NRW SUBMISSIONS FOR DEADLINE VI, 26TH MARCH 2015

1. These are the Submissions of NRW in relation to the ISHs between 17th and 19th March 2015 in relation to:
 - a) **ISH Policy Matters**, in particular Items 3 (Relationship between EN1 and 3 and TAN 8) and 5 (compliance with Policy);

- b) **ISH Landscape, Biodiversity and HRA**, in particular Items 2 (Landscape); 3 (Cultural heritage); 4 (Ecology); and 5 (Grid Connection).
 - c) **ISH draft DCO**.

Drawing file: EN010020 / EN010020-000774-MYG-ES-Fig12.19 - Bryn Llechese Fuches Wen Wireframe.pdf

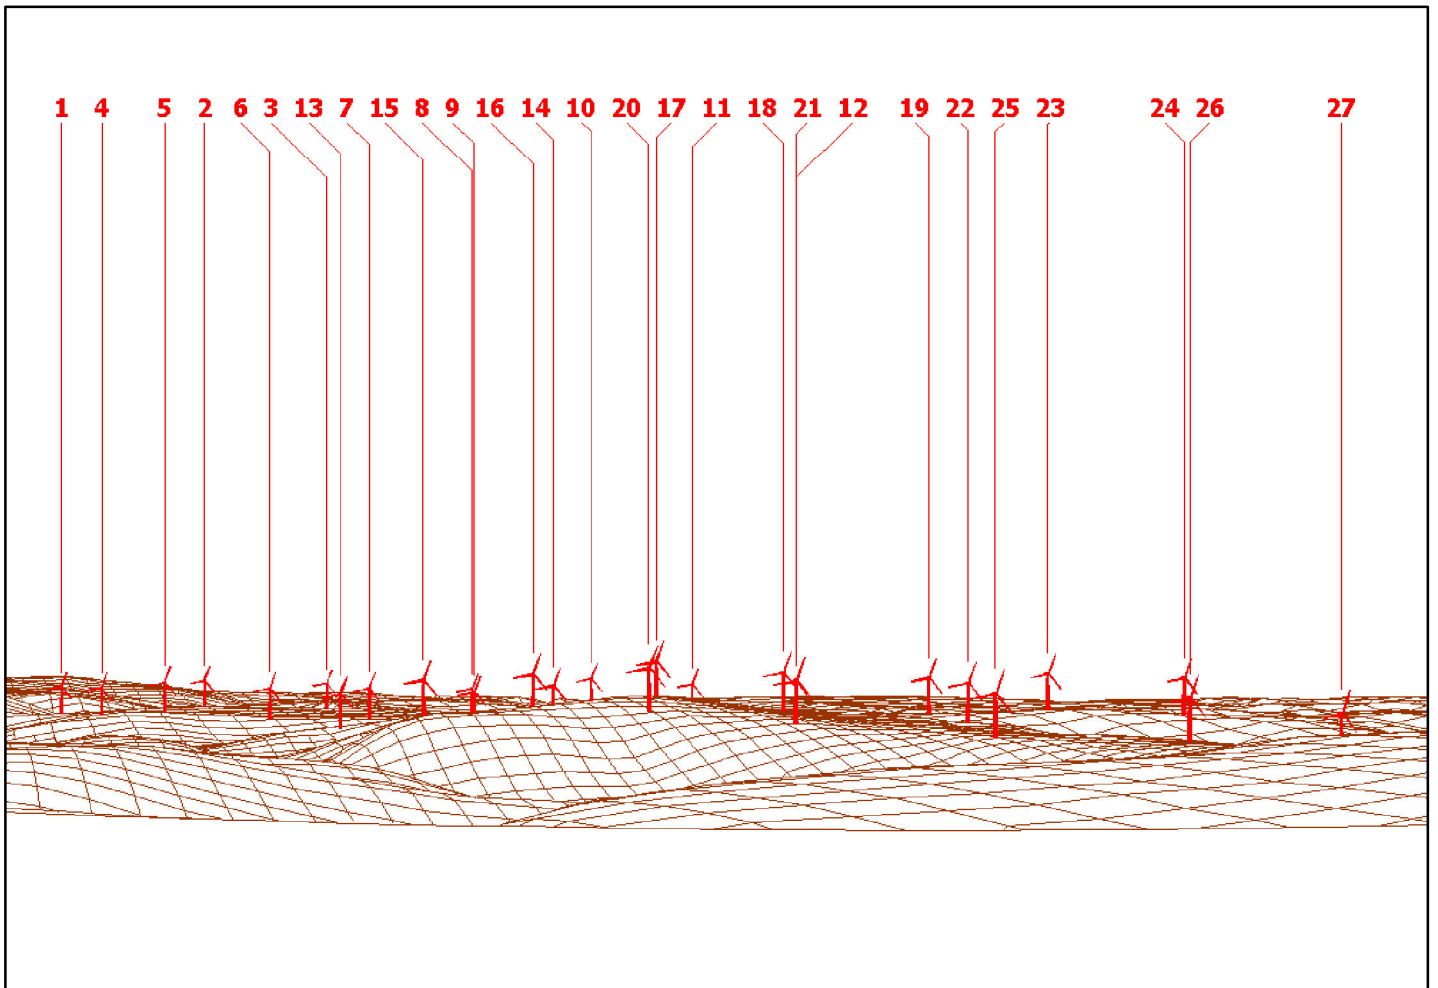
37. The Applicant's ASIDOL2 assessment at Tab 12.3 explains at paragraph 11 that it took account of "ZVT and wireframes" but there is no evidence that these visualizations were other than a 90m blade turbine. The Applicant's assessment is silent as to any consideration of EN-1 policy and its conclusions take no account of that guidance whatsoever.
